**Albuquerque Studios Master Plan
Development**

Traffic Impact Study

October 13, 2021

HT# R16DA3006A
received 1/3/2022

Synchro Arterial LOS on University Blvd North of Crick Ave

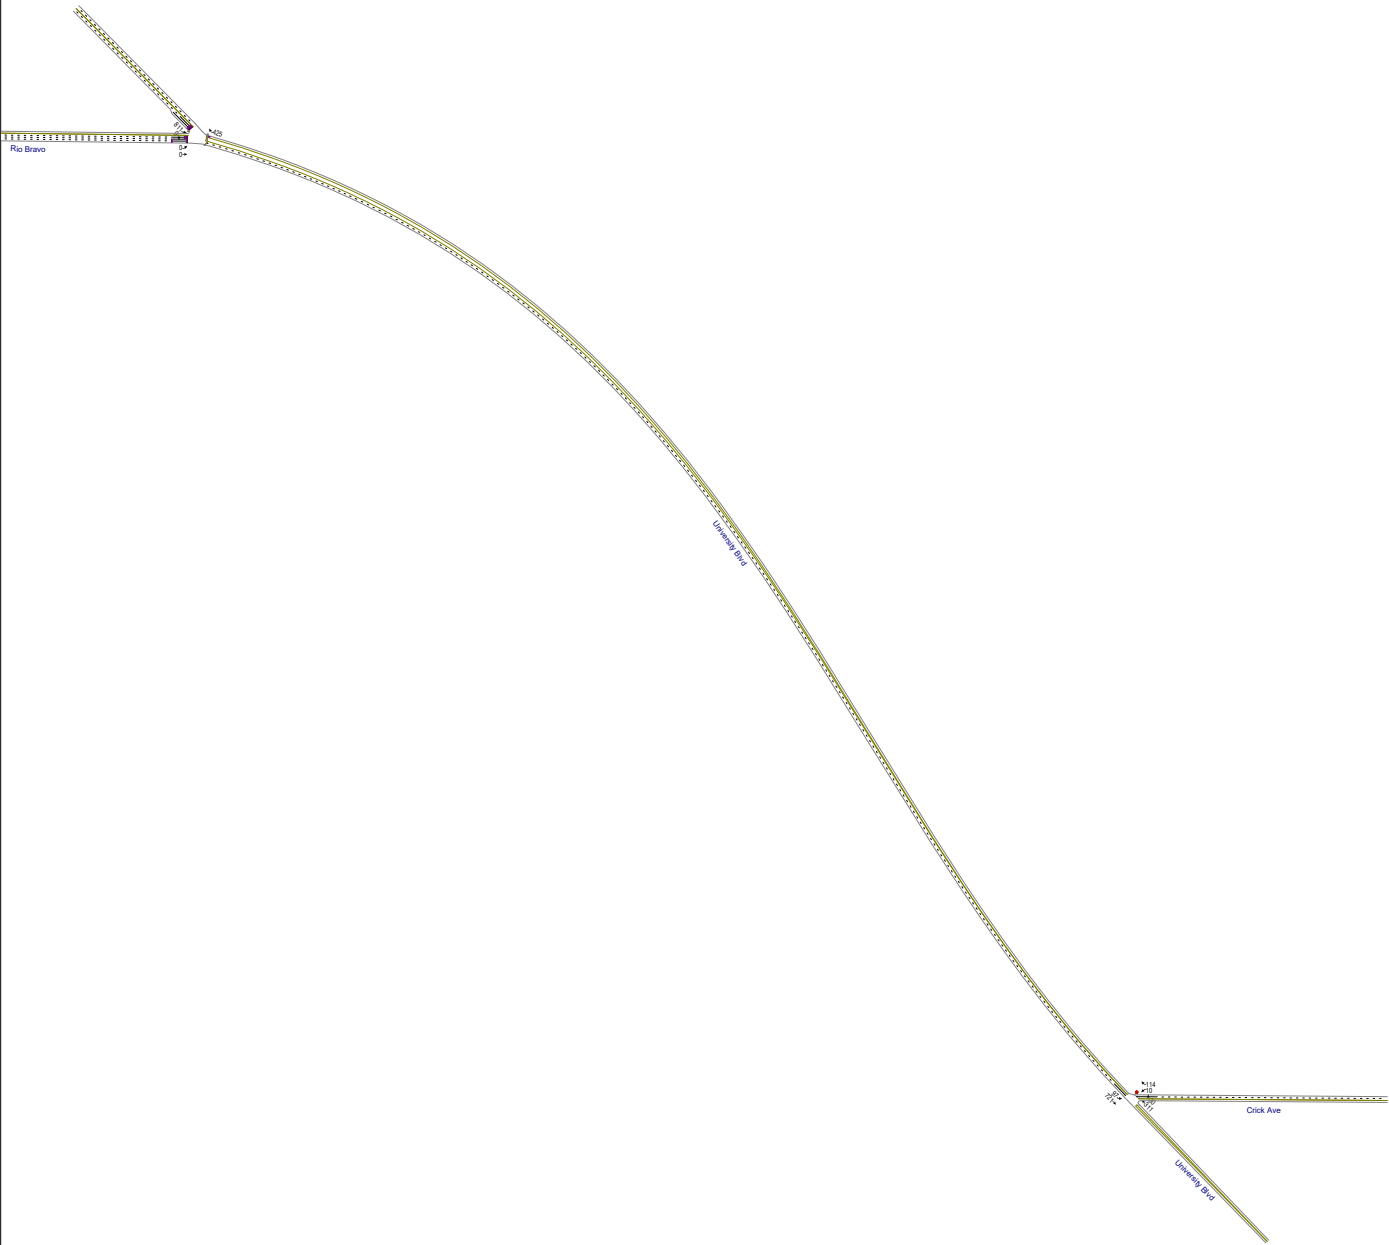
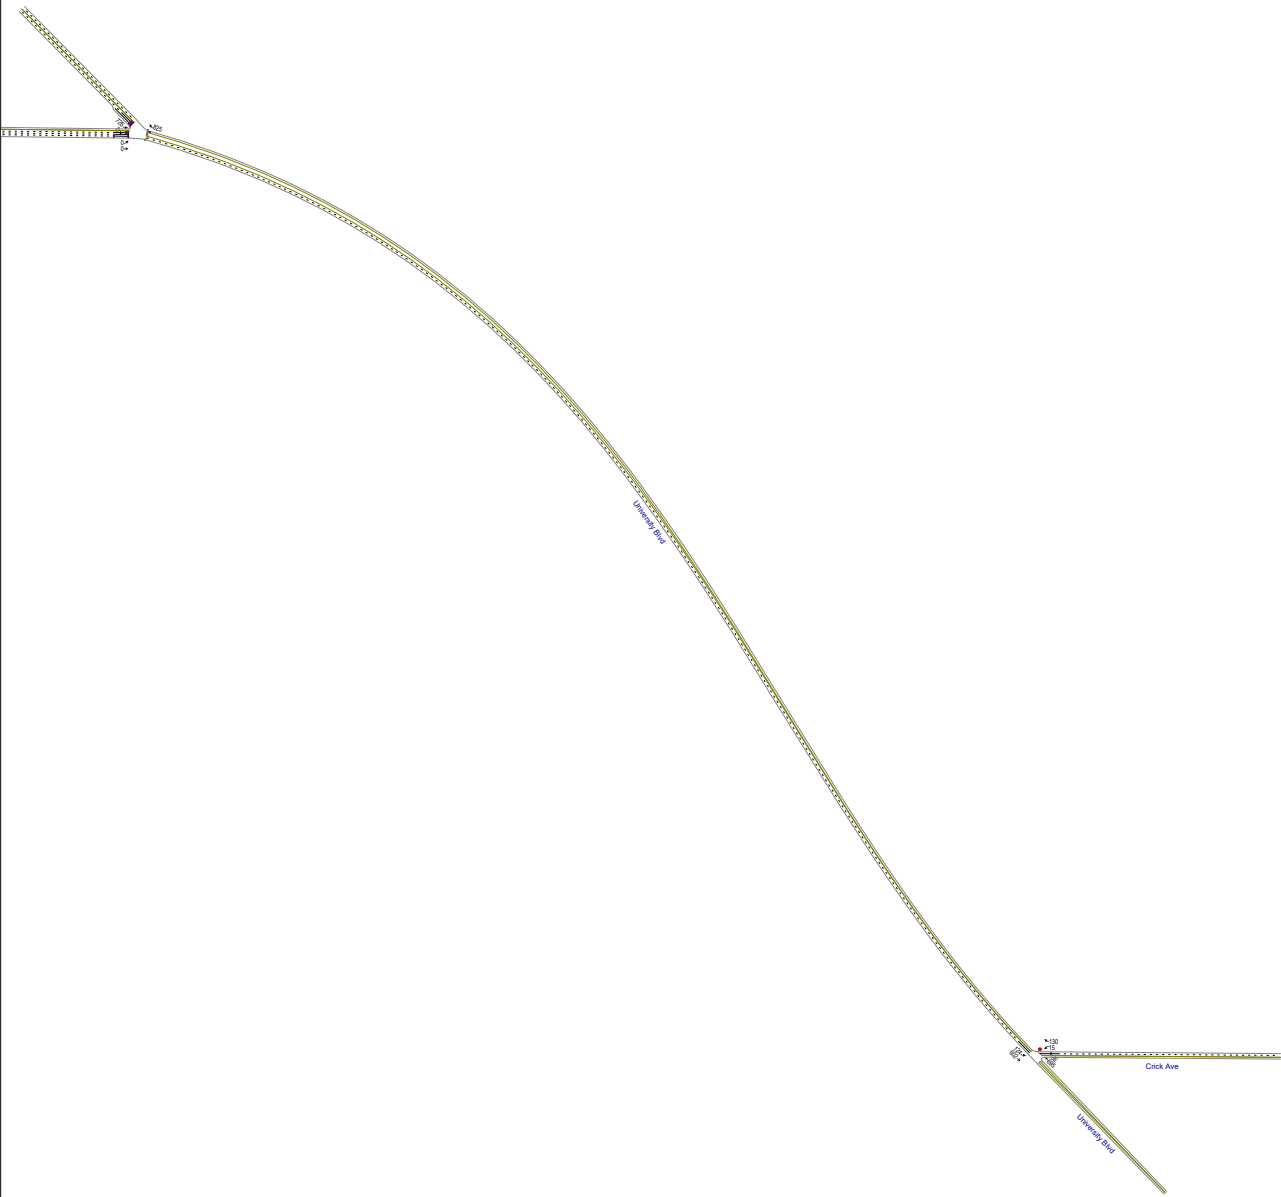
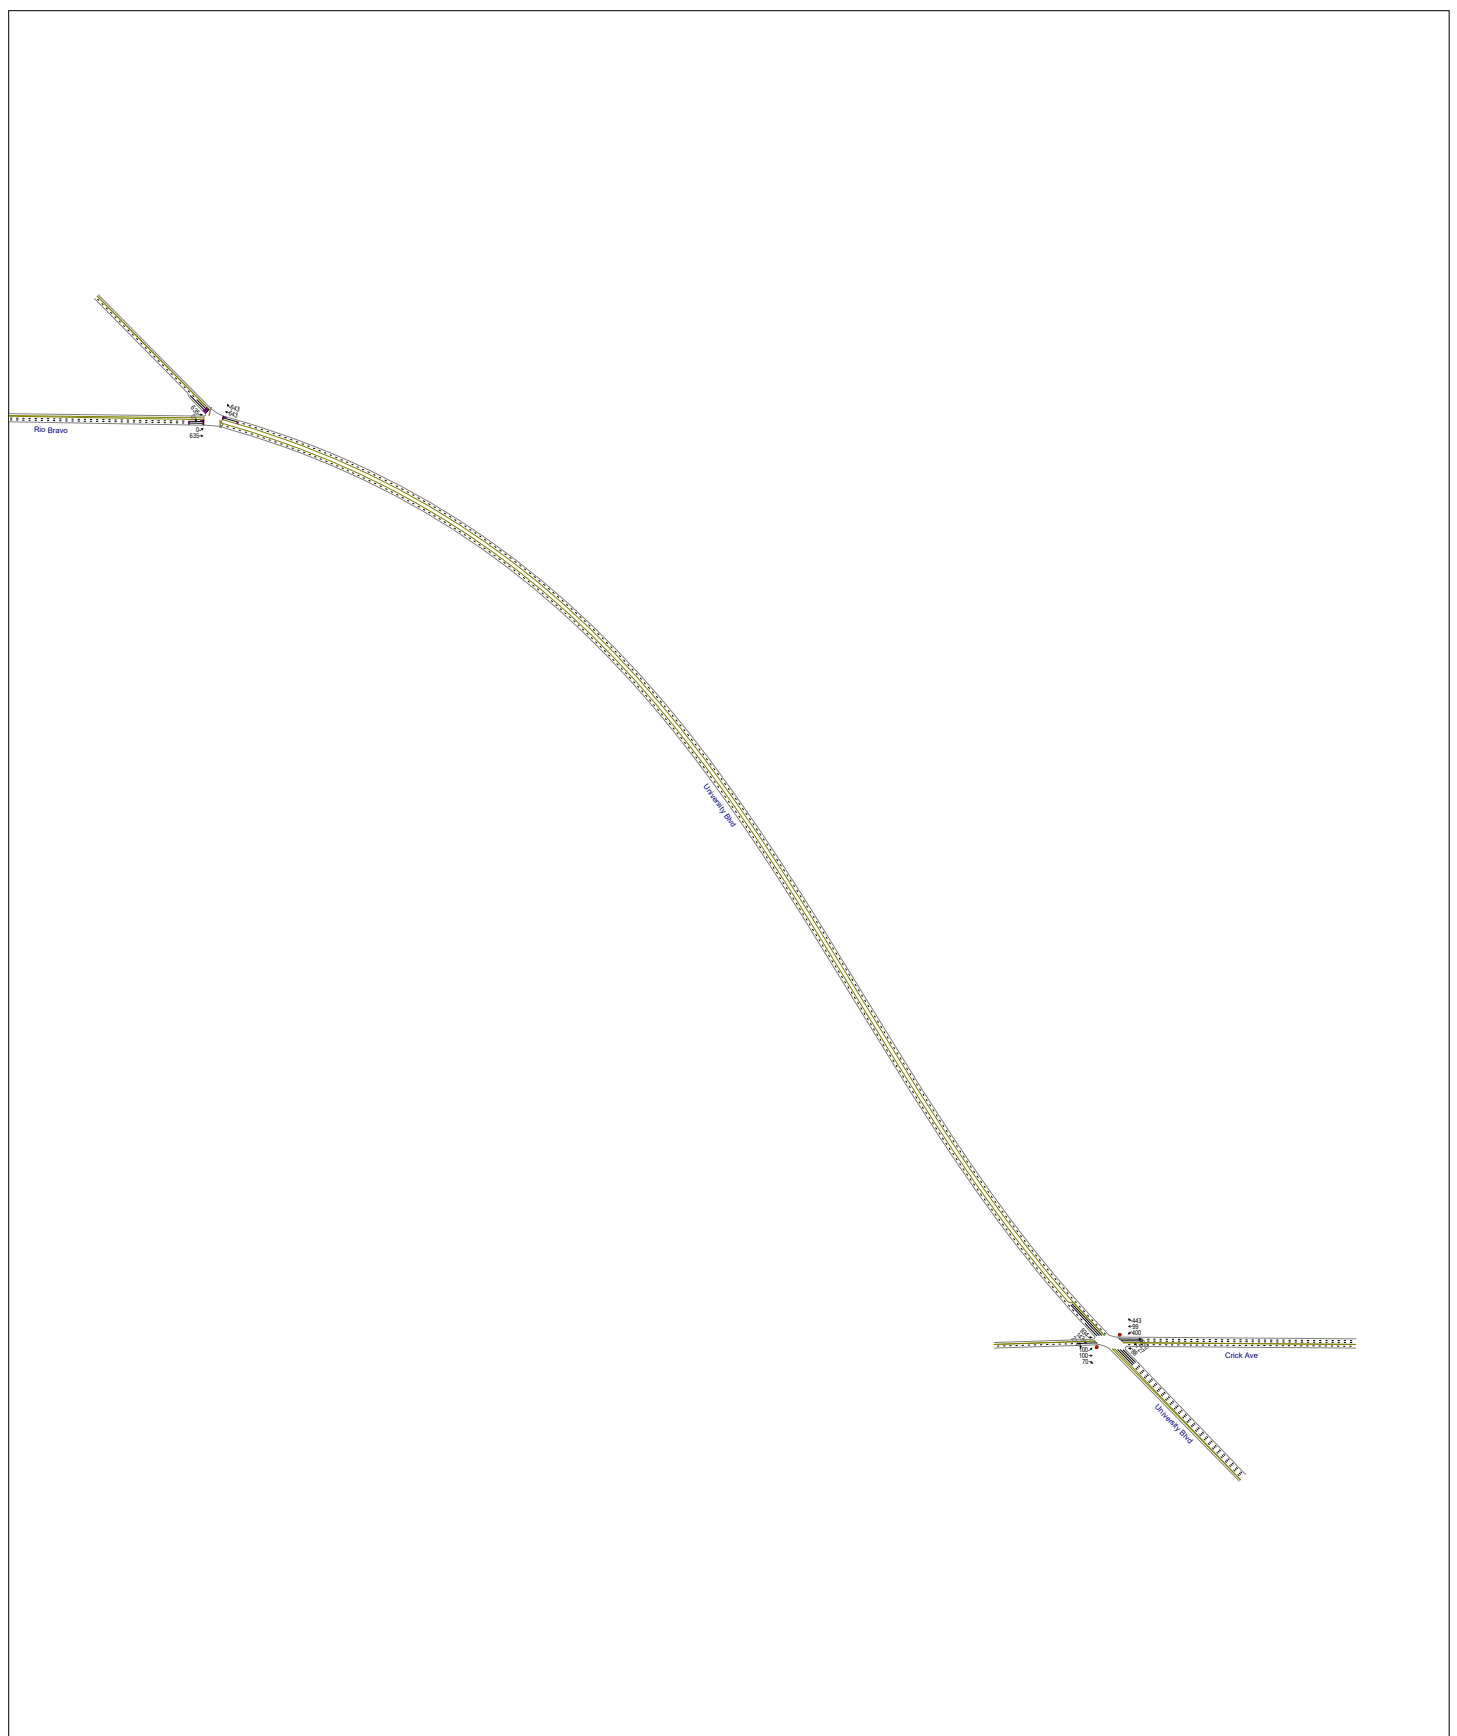
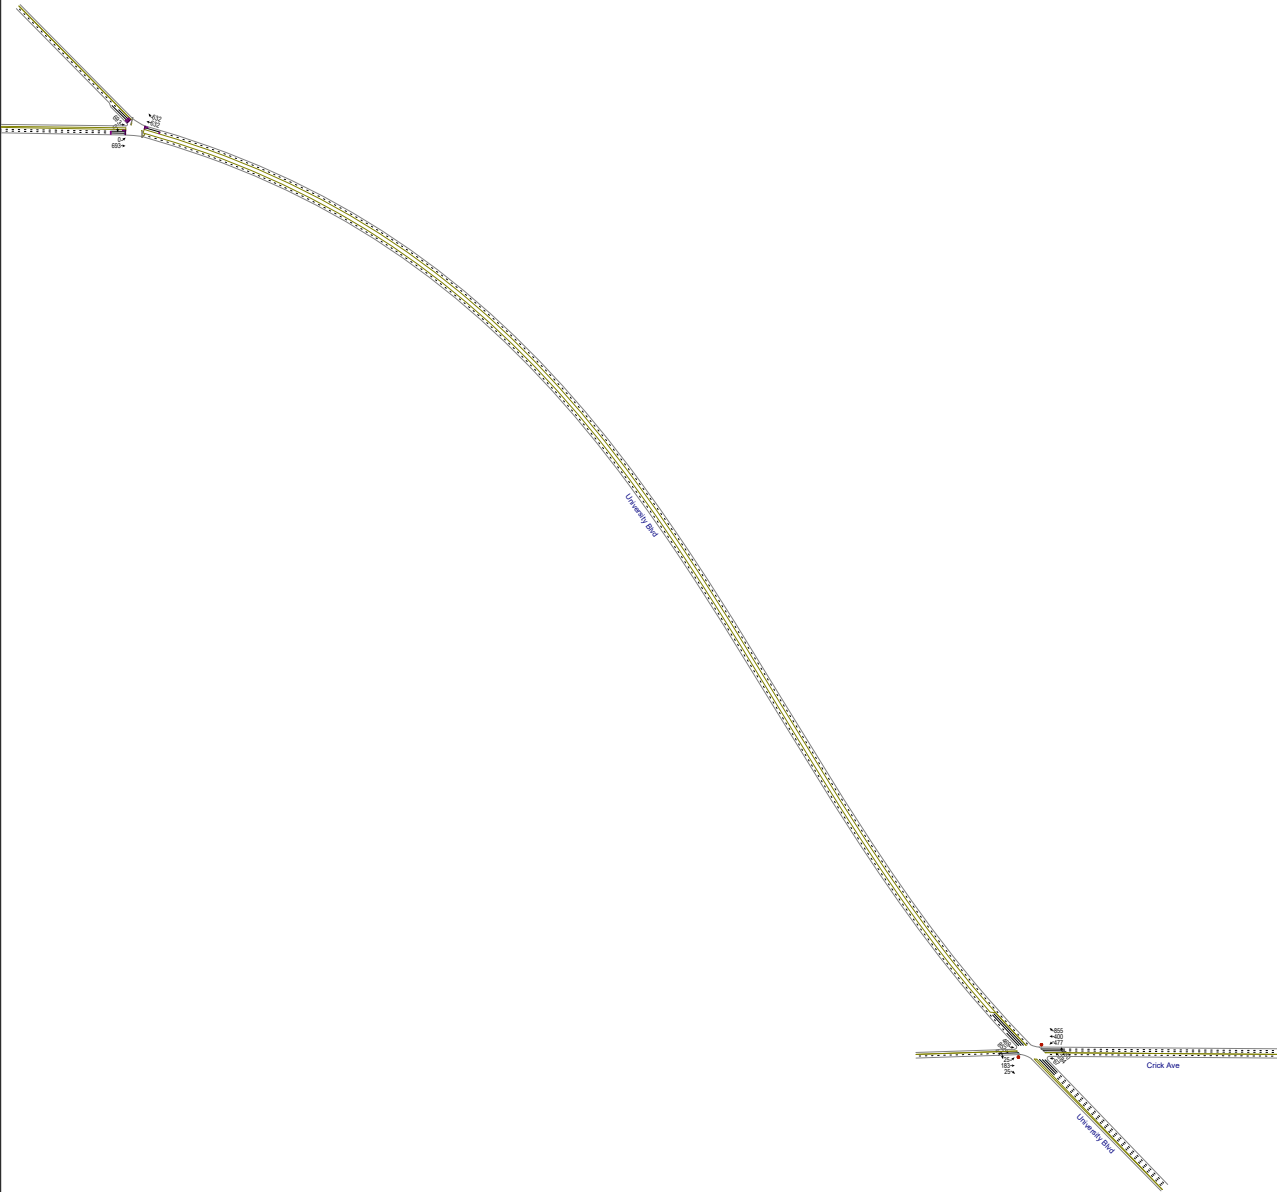
1. Evaluate the LOS on University Blvd. north of Crick Ave. This should include the traffic from the Montage developments and the Bernalillo County athletic fields, if the data is available. If the other development's trip distribution and traffic volume is not available perform the LOS for University using the background and build year traffic from the Netflix development. Provide mitigation suggestion if needed.

*A summary of Level of Service (LOS) (Arterial) for University Blvd. north of Crick Ave. is provided below: *Synchro Analyses report is attached.*

<i>Implementation Year Peak Hour AM, PM</i>	<i>Horizon Year Peak Hour AM, PM</i>
<i>University Blvd</i>	<i>LOS A, LOS A</i>	<i>LOS C, LOS C</i>

Note: Additional at-grade signalized intersections that may be proposed north of Crick Ave in the future on University Blvd., will reduce the green time available to the major street (University Blvd). Currently University Blvd is operating in an un-interrupted flow condition (no traffic signals). Installation of traffic signals in the future may increase the need for additional approach lanes at the signalized intersection on University Blvd. to maintain/achieve an acceptable delay LOS thru the intersection during the peak hour conditions.
